Erection of four terraced residential dwellings, garden/cycle storage sheds & associated car parking, utilising the existing access - This application may affect the character & appearance of The Steyne, Bognor Conservation Area & will affect the setting of a Listed Building

Former hotel tennis courts adj to The Royal Norfolk Hotel West Street Bognor Regis

Thank you for your internet representation made on 21st November 2018 which has been recorded as '**an objection**' with the comments as follows:

Drg No: **RNHB.PLAN 5**

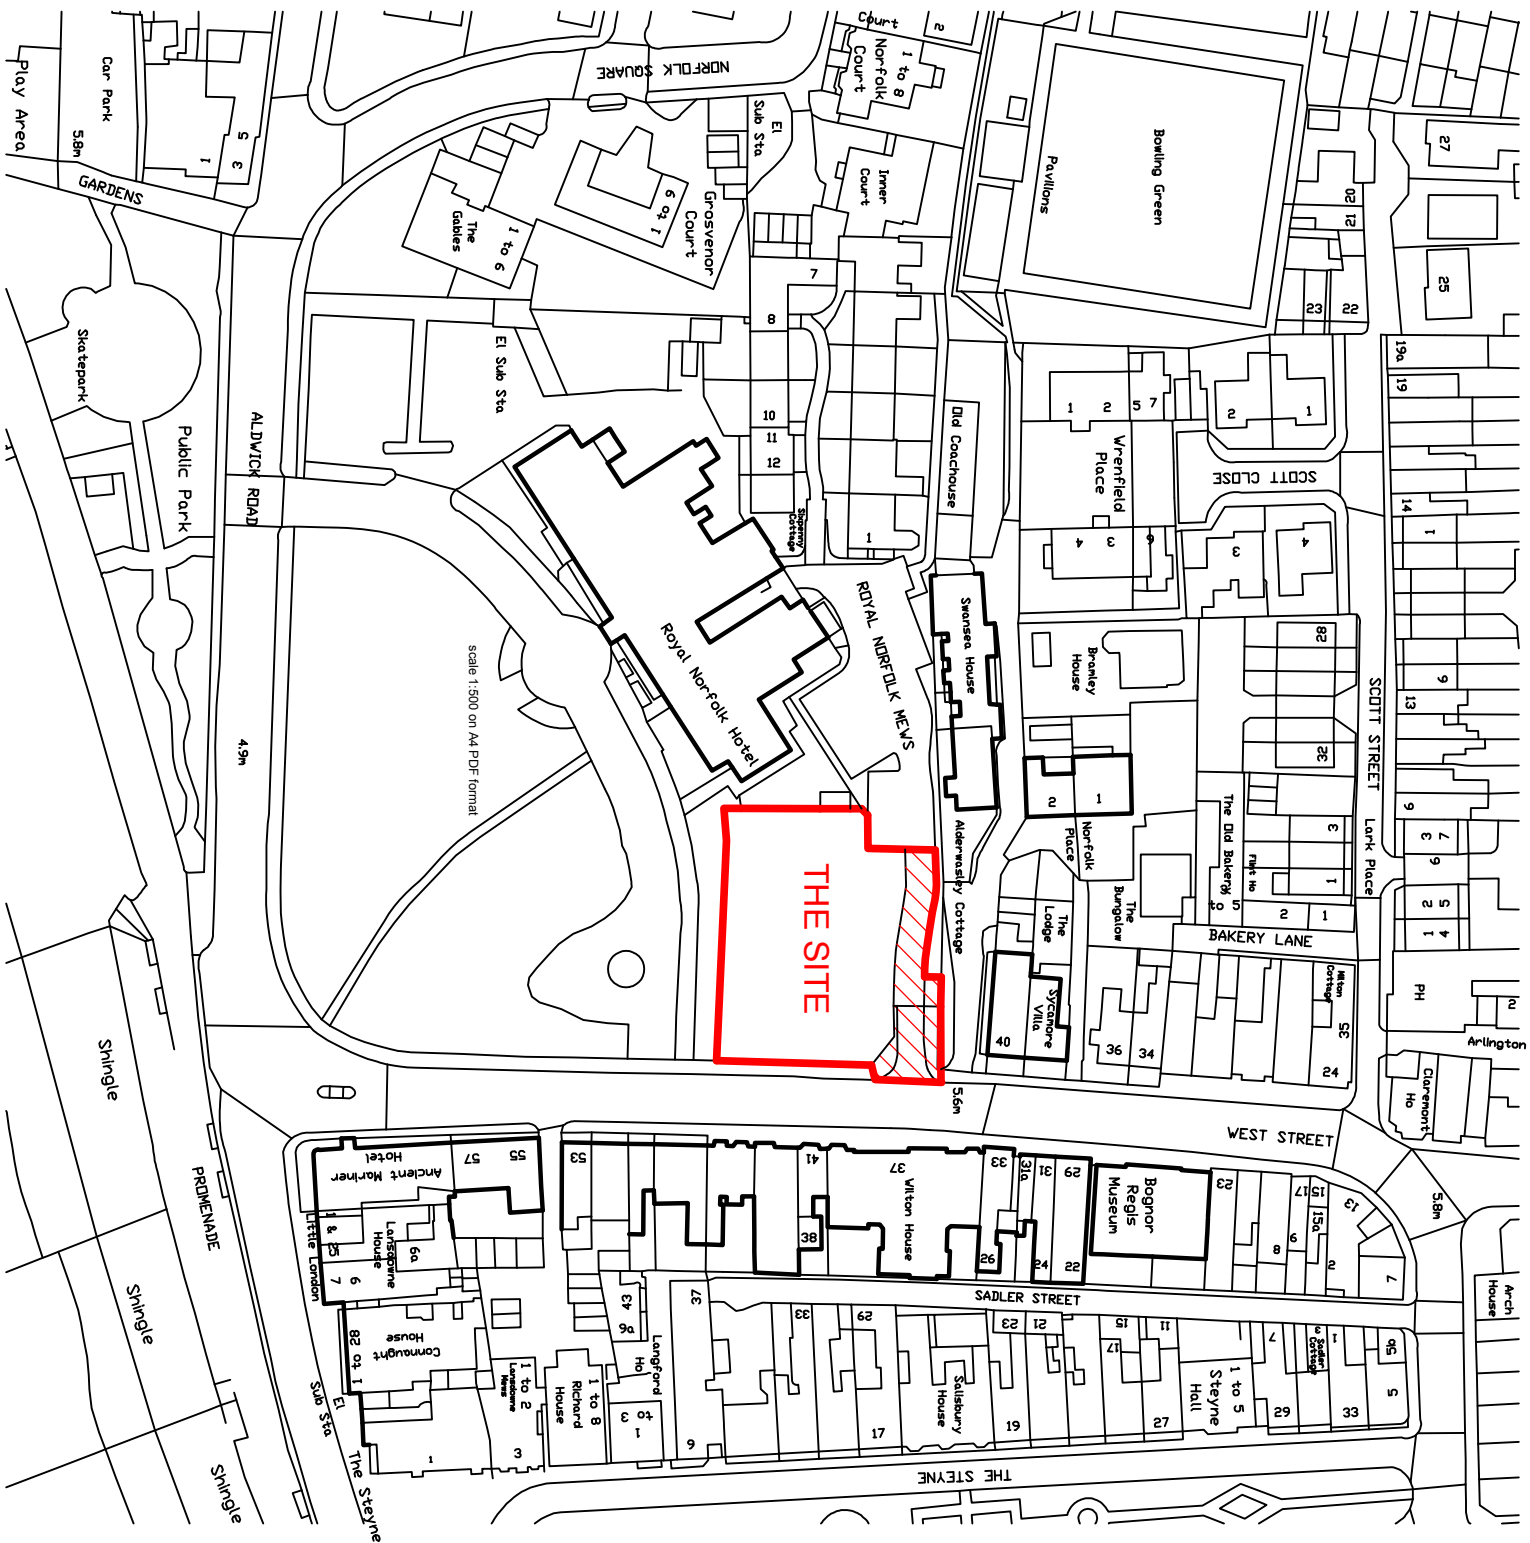
The Royal Norfolk Mews Management Ltd (RNMM Ltd) owns the access drive and adjoining land to the current Mews, known as the Royal Norfolk Mews, on which the access to the proposed development will run.

The transfer document of 8th May 2008 includes a covenant giving the transferor right of access over the entrance road through an entrance to the retained land in a position to be agreed between the transferor and the transferee. This agreement was reached and the existing wooden gates were erected and a dropped kerb installed for access to the retained land. The layout of the Royal Norfolk Mews took this into account. However, the new plans deposited with Arun DC ignore this agreed positioning and place the entrance at the western extremity of the development to the detriment of the visitor parking owned by RNMM Ltd. This is unacceptable and the plan should be adjusted to reinstate the previously agreed entrance.
